# Markup Summary

SHEET NO 11-136

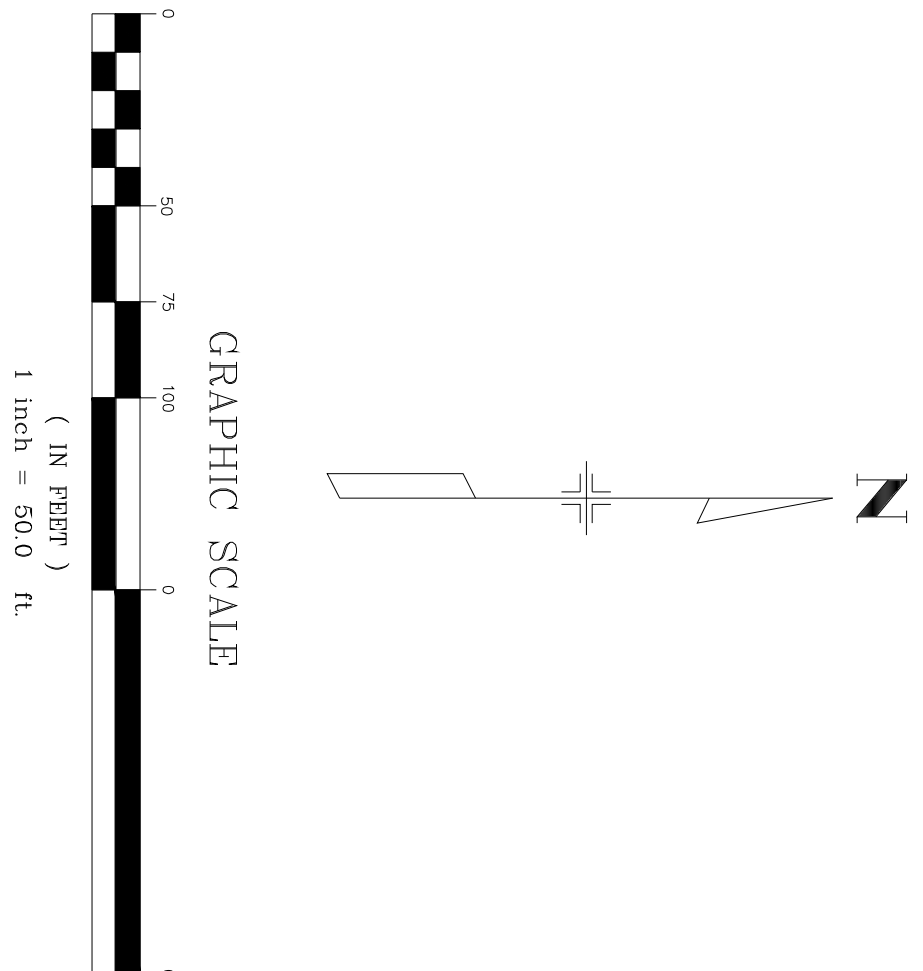
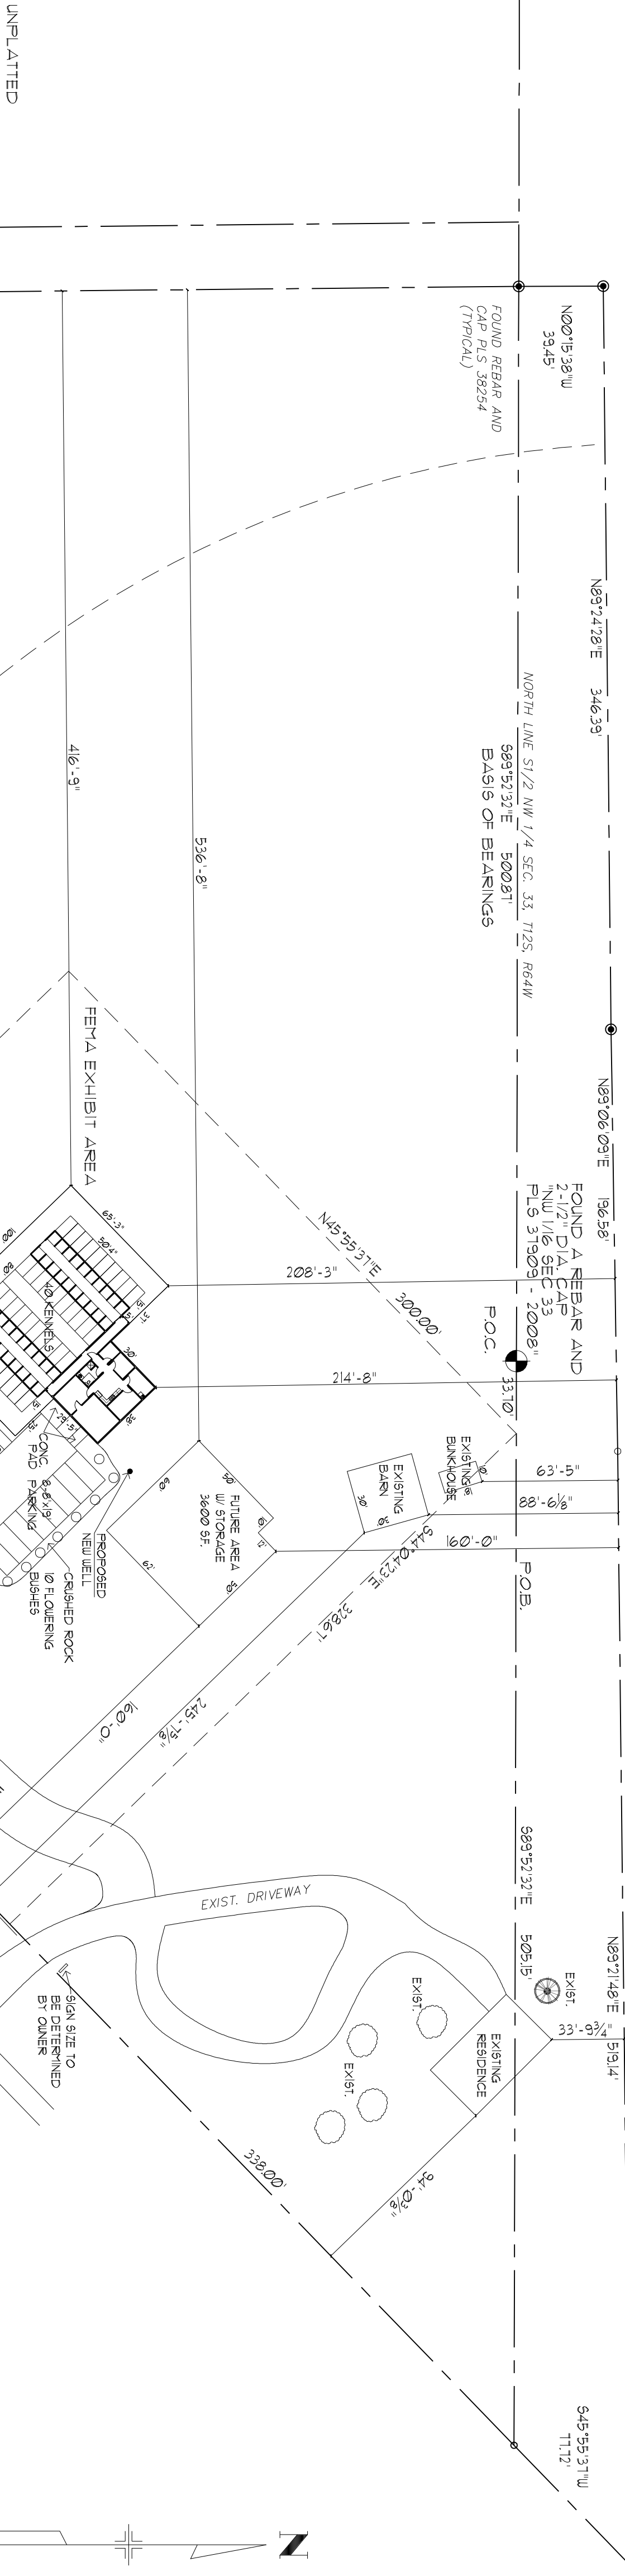
Show dimensions of the structures and fences

Measure from here

Access? to what

Measure from the fence

Aren't 60 kennels being proposed? does future 28 mean 88 total kennels?
